From: Amanda Scholes on behalf of Planning.Responses
Sent: 31 March 2017 08:40
To: Planning Scanning
Subject: FW: Planning Consultation on: LU/56/17/PL

LU/56/17/PL

Site Address: 22 Beach Road & 3 Evans Gardens Littlehampton BN17 5HT

Description of Works: Change of use of ground floor from retail shop (A1 Shops) to hot food takeaway (A5 Hot Food Takeaway) & associated works.

EXTRACT DUCT POSITION

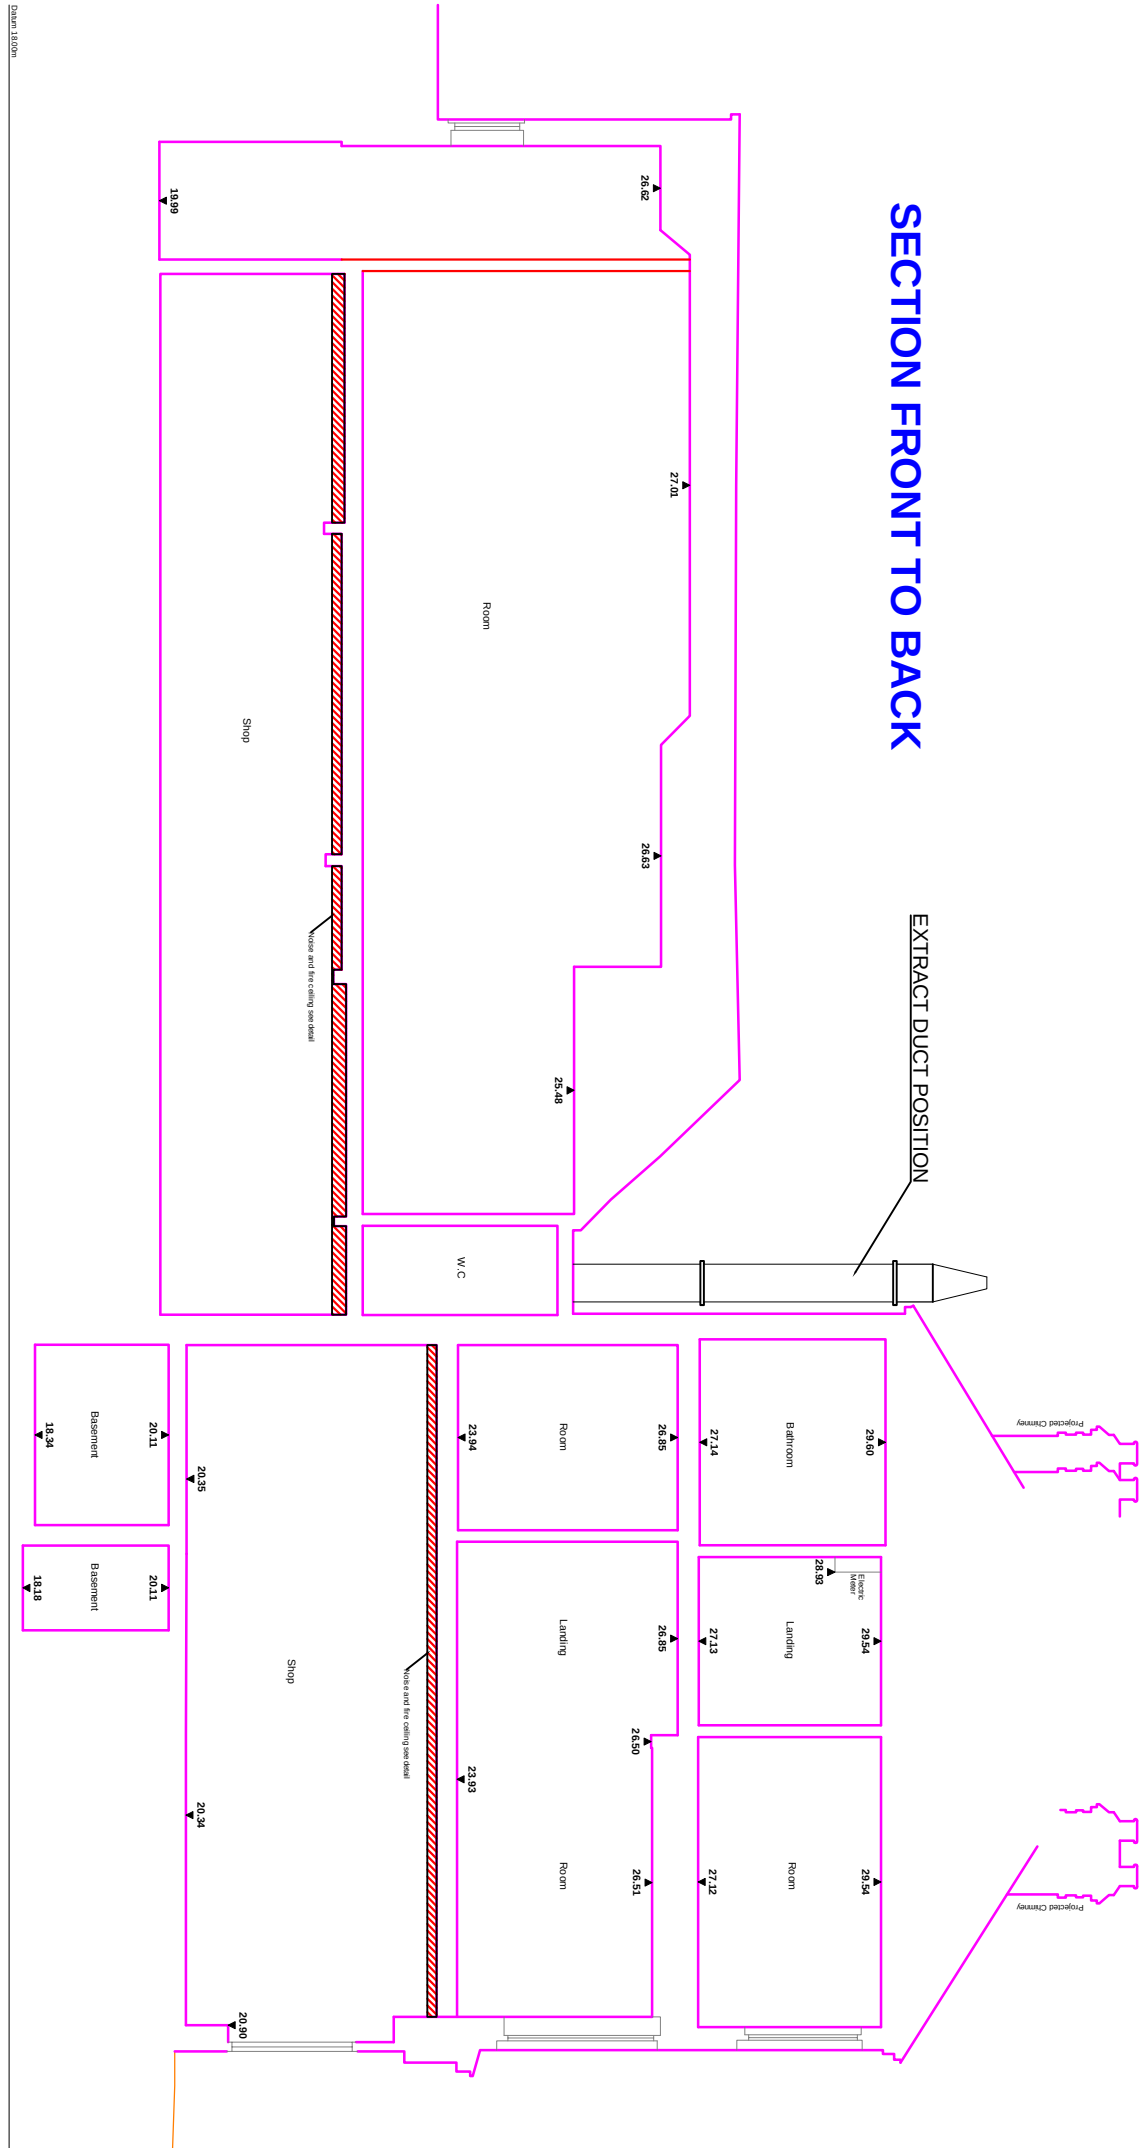
Environmental Health Comment: An Acoustic Report will be necessary in respect of delivery vehicles, particularly delivery mopeds; and plant, to be used in association with this premises in order to demonstrate that the proposed business will not cause noise nuisance to the nearest noise sensitive location.
